Subject: Sundown Solar Farm – Response to Submissions – SSD-8911 (Inverell Shire)

ATTACHMENT A CPHR comments on Sundown Solar Farm (SSD 8911) - Response to Submissions

Sundown Solar Farm
Submissions Report
Figure 3.1

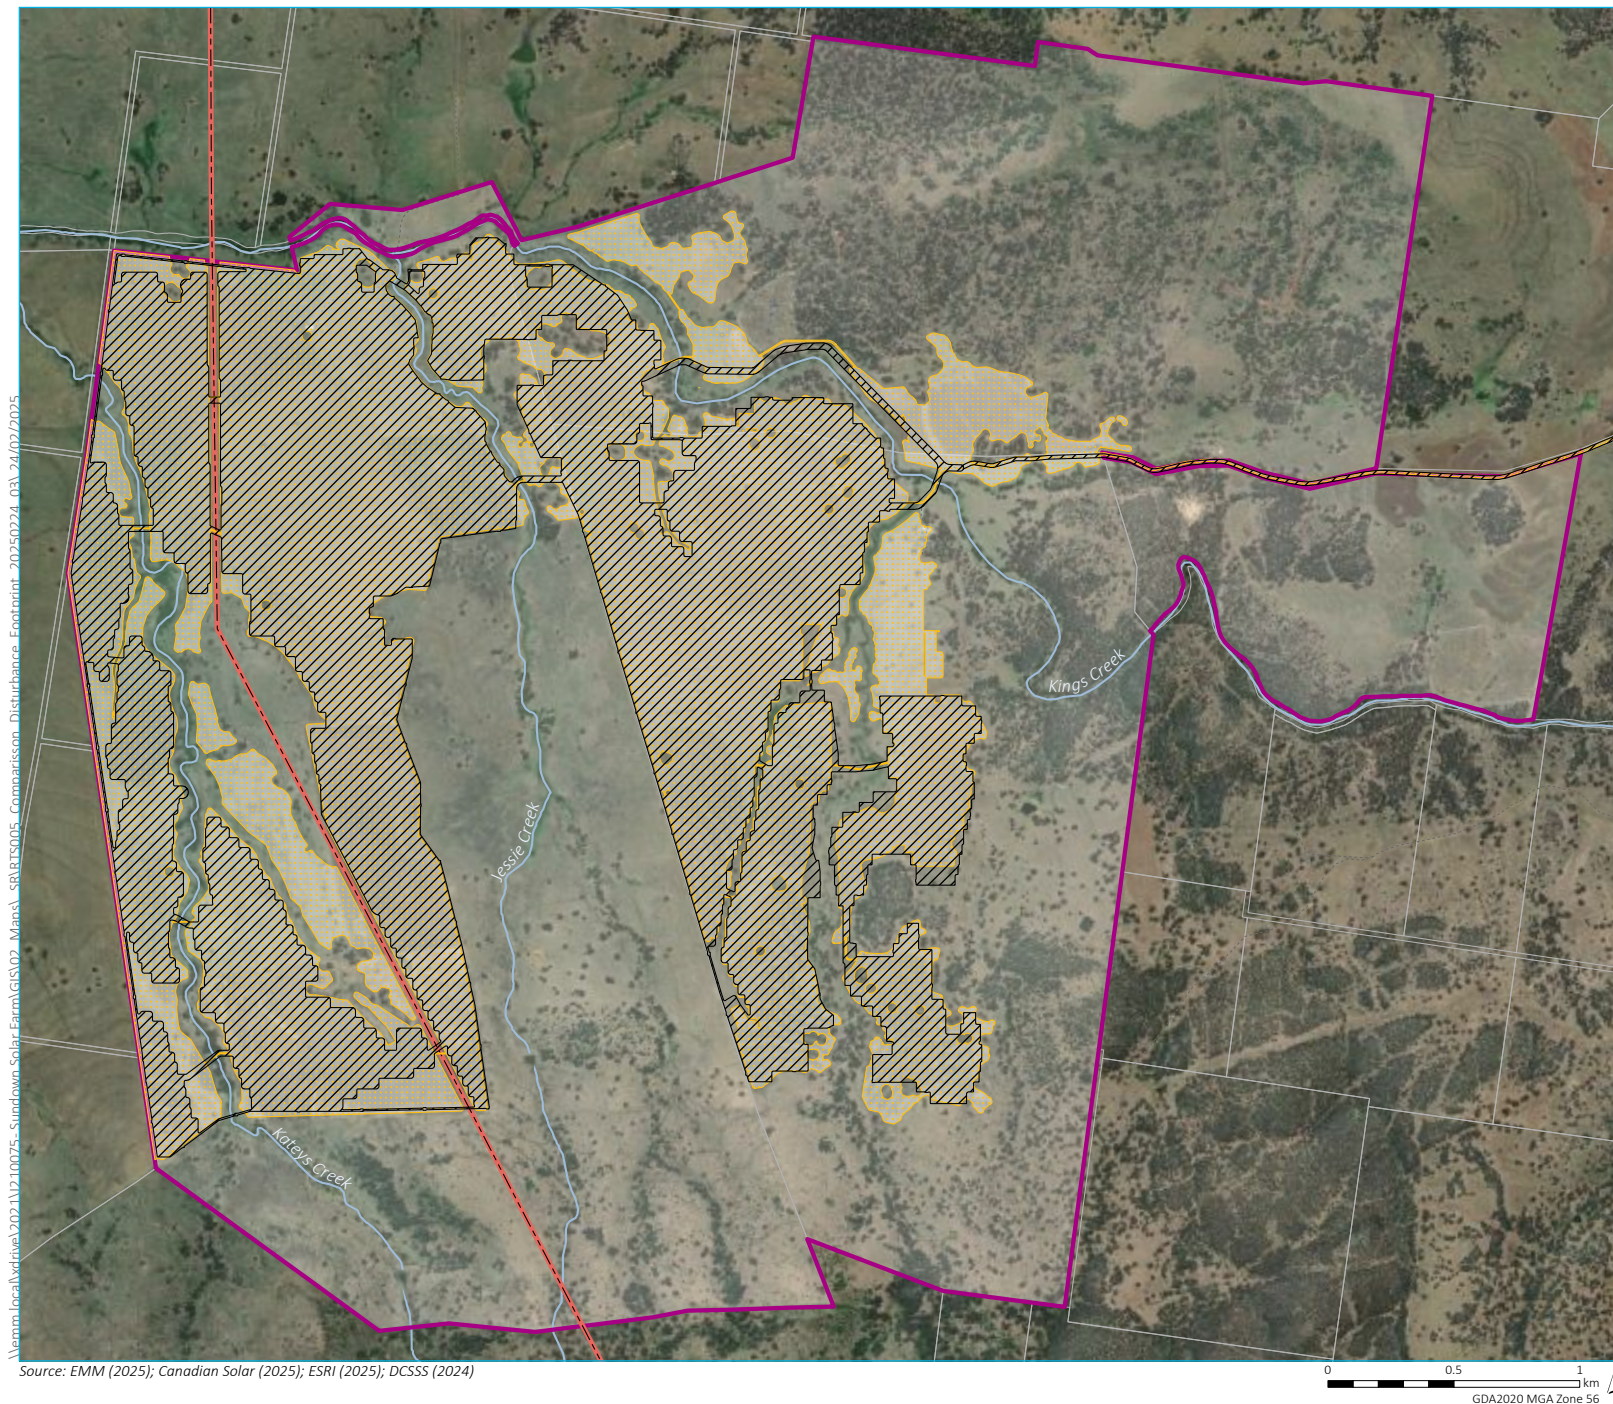
The remaining key issue relates to the proposed perimeter fencing. The proposed fencing locations are not presented in the documentation, and therefore it is unclear if the associated impacts have been assessed in the Biodiversity Development Assessment Report.

CPHR RTS 1	Issue	Further detail on the proposed perimeter fencing is required
	Detail	Project design revisions proposed in the RTS include a perimeter fence around the PV modules. The Amended BDAR states the perimeter fence layout was designed to ensure that connectivity values would be maintained in the study area, however the location of the proposed fencing is not presented in any figures. To confirm the proposed perimeter fencing would not impact habitat connectivity and that it is within the development footprint assessed in the Amended BDAR, mapping of fence locations and details on the proposed type of fencing and crossing points are required.
	Recommend	Prior to determination, further detail of the proposed perimeter fencing is provided to demonstrate any associated impacts have been assessed.
